# ENG-SP20008-R4-PDR-redlines.pdf Markup Summary

PRELIMINARY GRADING PLAN

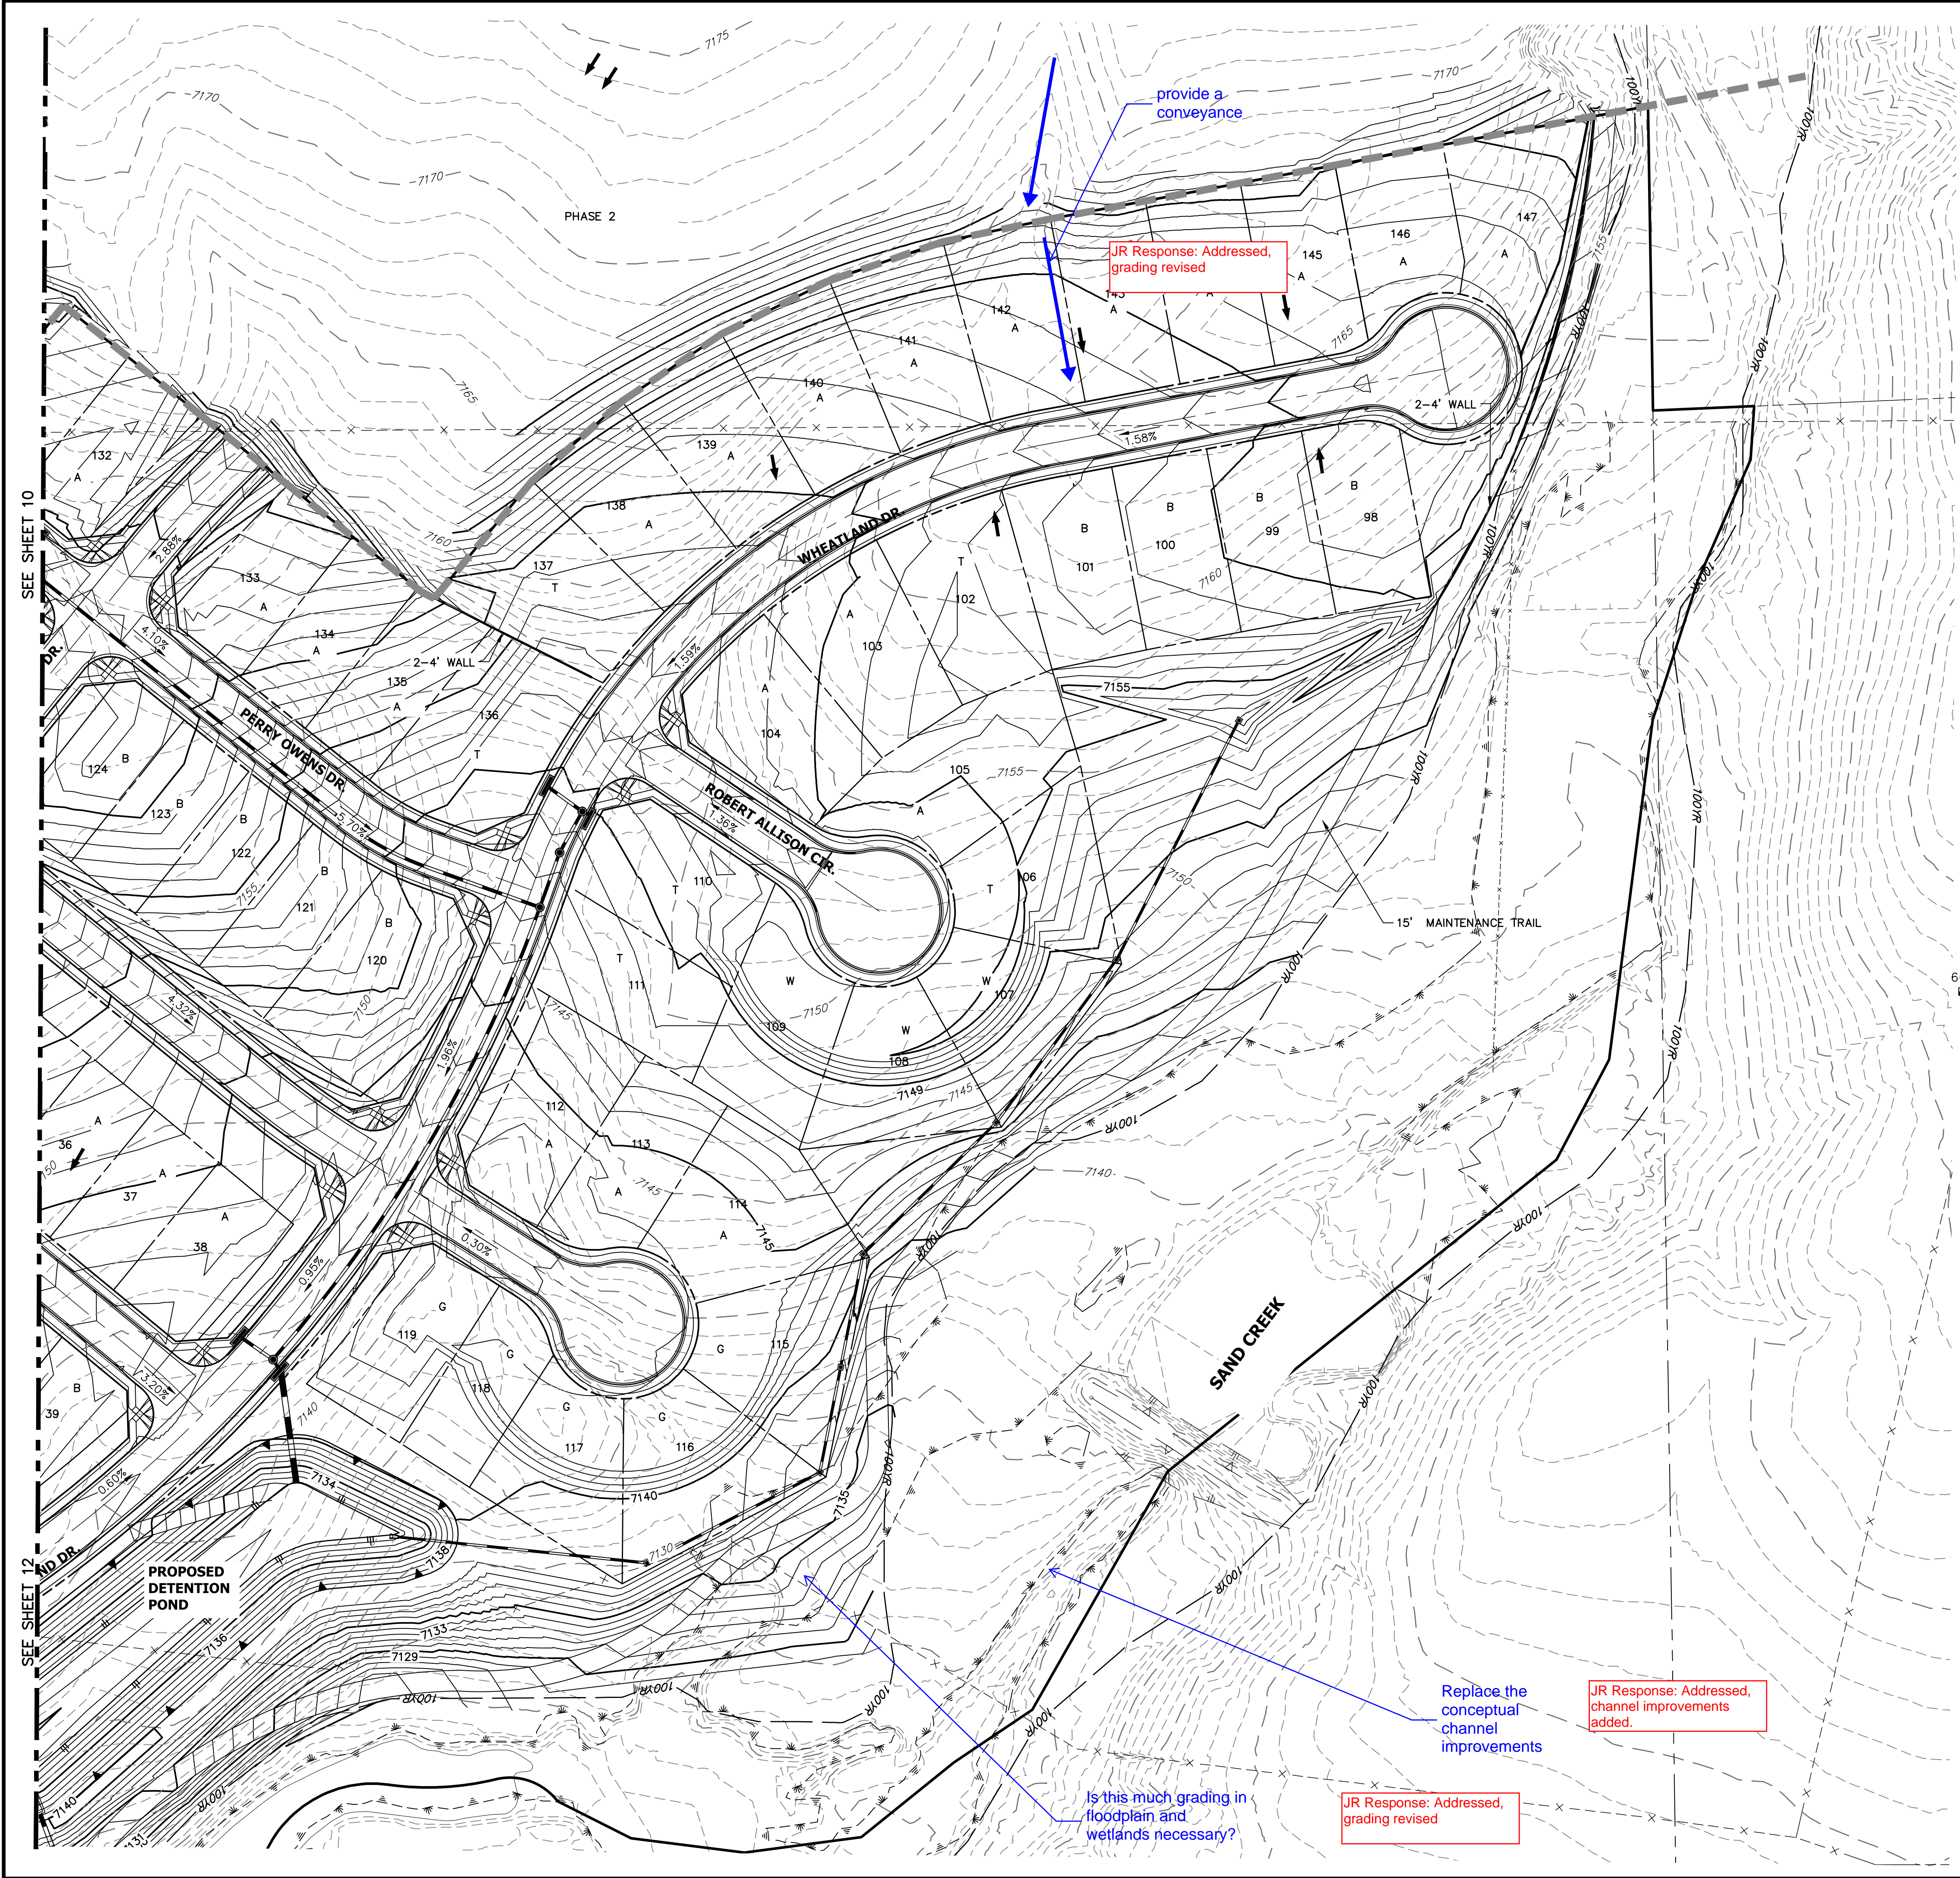
Include a minimum depth on all swale details

With this velocity, need a permanent lining, not temporary

Do not show curb and gutter on grading

The proposed contours should not show curb, gutter and median

Erosion protection needs to go into the bottom of the channel
